**WEST SUSSEX COUNTY COUNCIL
STRATEGIC PLANNING CONSULTATION**

SUBJECT: EP/111/12 - Demolish 1 house (60 Sea Lane); partially demolish 1 house (45 The Ridings);
construct 3 detached houses; alterations and extentions (45 The Ridings).
SUBSTITUTE PLANS REC'VD; 100B, 101A, 102A, 103A, 104A, 105A, 106A, 107A.

45 The Ridings, 60-62, Sea Lane, East Preston, West Sussex, BN16 2TW

SITE, BLOCK & LOCATION PLAN

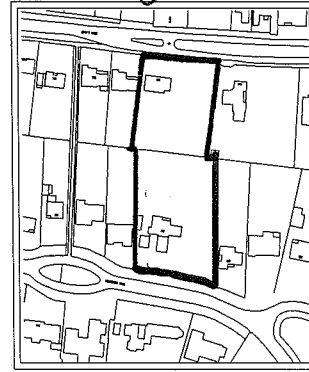
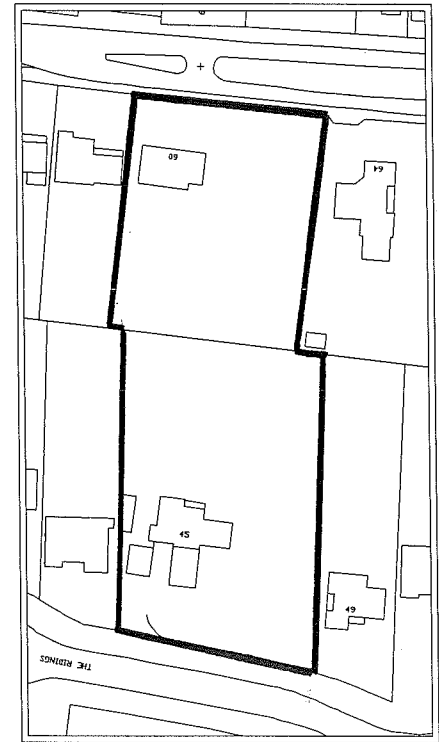
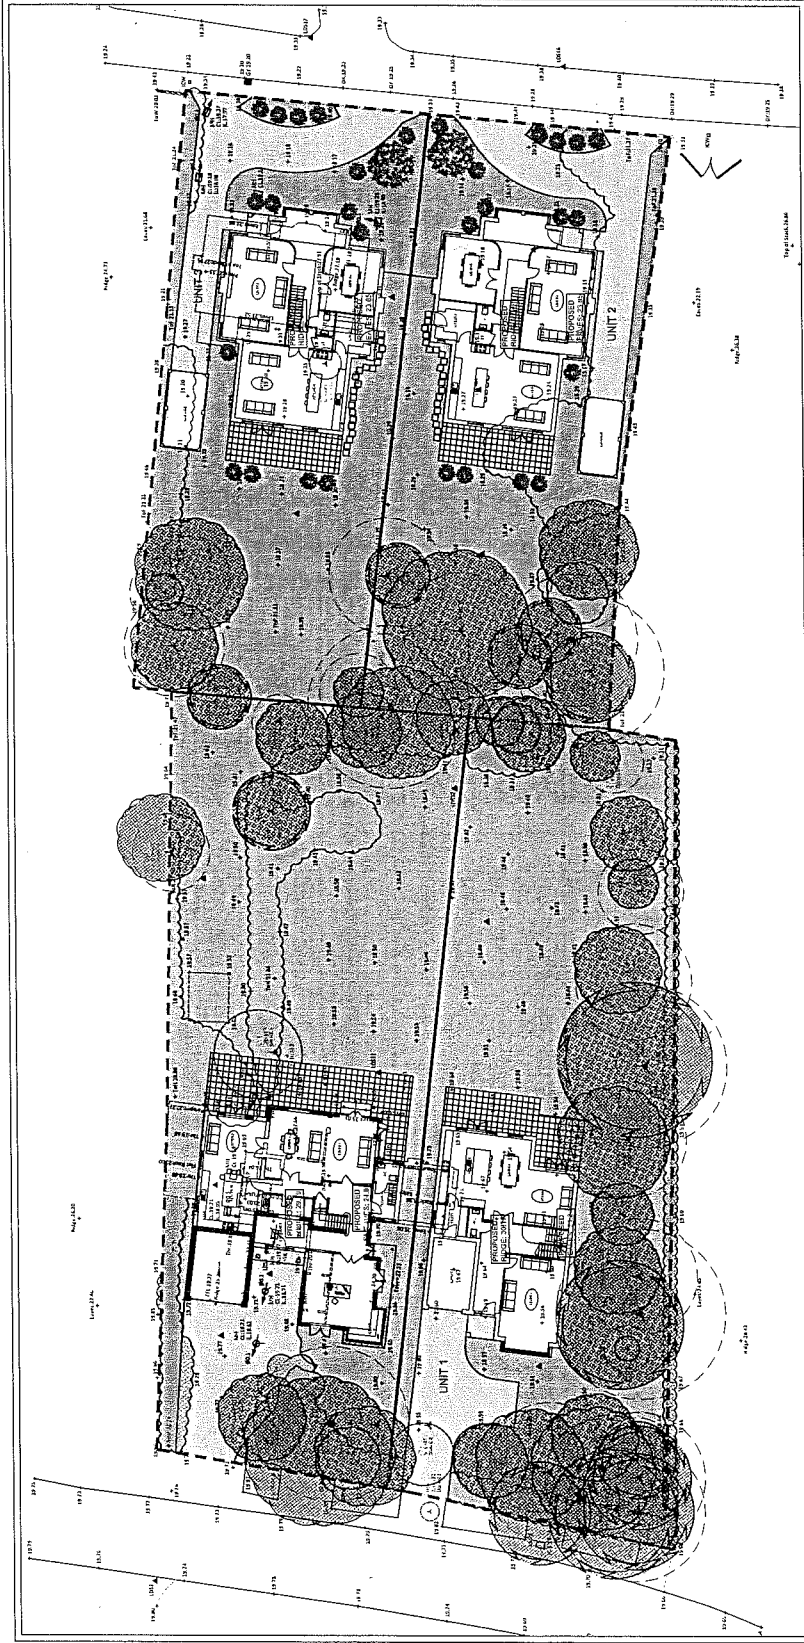
It has been noted that substitute plans have been submitted with an improved visibility splay for "unit 2" on Sea Lane. Whilst this modified access does improve the visibility to the required standards the dwelling has now lost the required turning area to enable vehicles to enter and egress the site in a forward gear. Therefore a further modified plan is required to be submitted for the Highway Authority's approval. A swept path analysis diagram is requested to be submitted at the same time.
